Martin Nugent
01254 828060
D3/11/1064

Drafted 31 May 2012

**Outline Planning Application, Ribble Valley District
3/11/1064 Primrose Mill (second phase) and Woone Lane, Clitheroe**

AMENDED PLANS RECEIVED
 DATE 17 MAY 2012

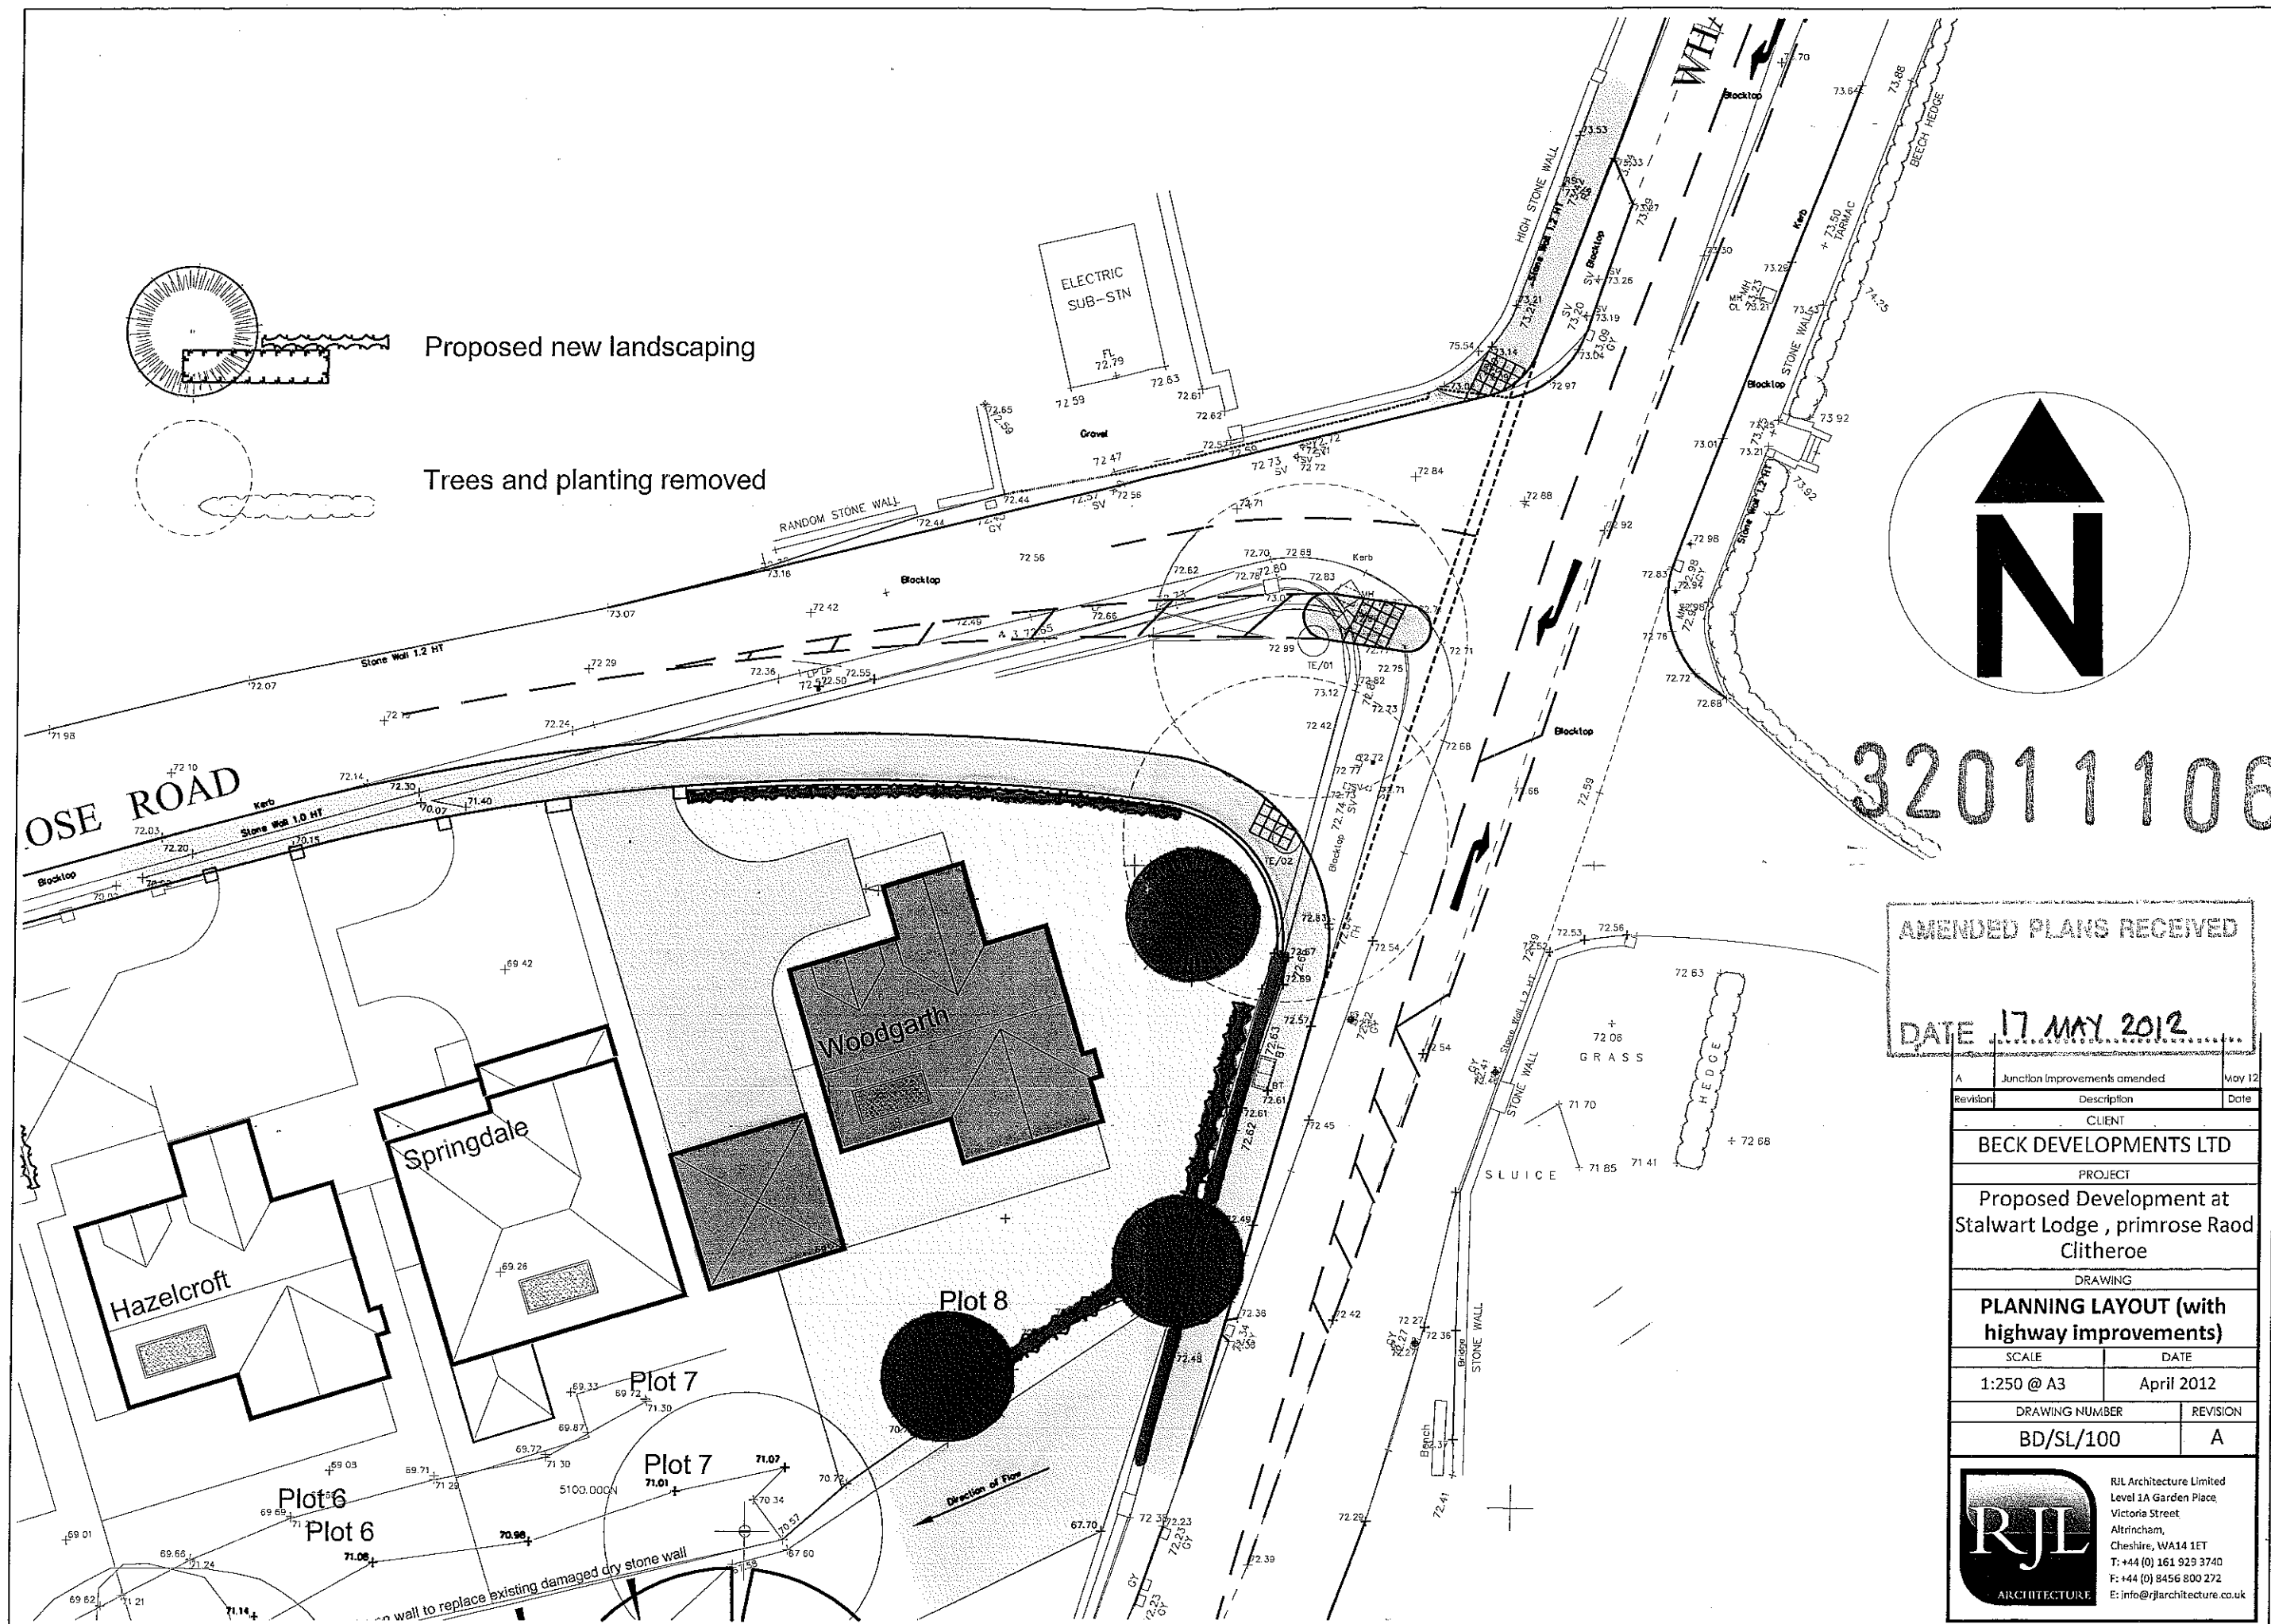
Further to this, a revised highway layout was submitted by the applicant on 17 May 2012. The most significant impact of this revision is that there would be no local widening of the highway and no setting back of the footway along the east side of Whalley Road.

I have no objection to such a revision in principle, but the subsequent highway design must be consistent with basic criteria for the operation of the junction that allows it to function safely and efficiently for all road users. The layout shown in Drawing BD/SL/100 Rev A does not comply with basic design principles, as set out in the Design Manual for Roads and Bridges, Volume 6 (most recently updated November 2011). The preferred width for the right turn lane would be 3.0m, but the minimum acceptable width for this location would be 2.5m.

I would request that a further drawing is provided that establishes a junction layout that corresponds to the essential highway design criteria for a right-turn ghost-island.
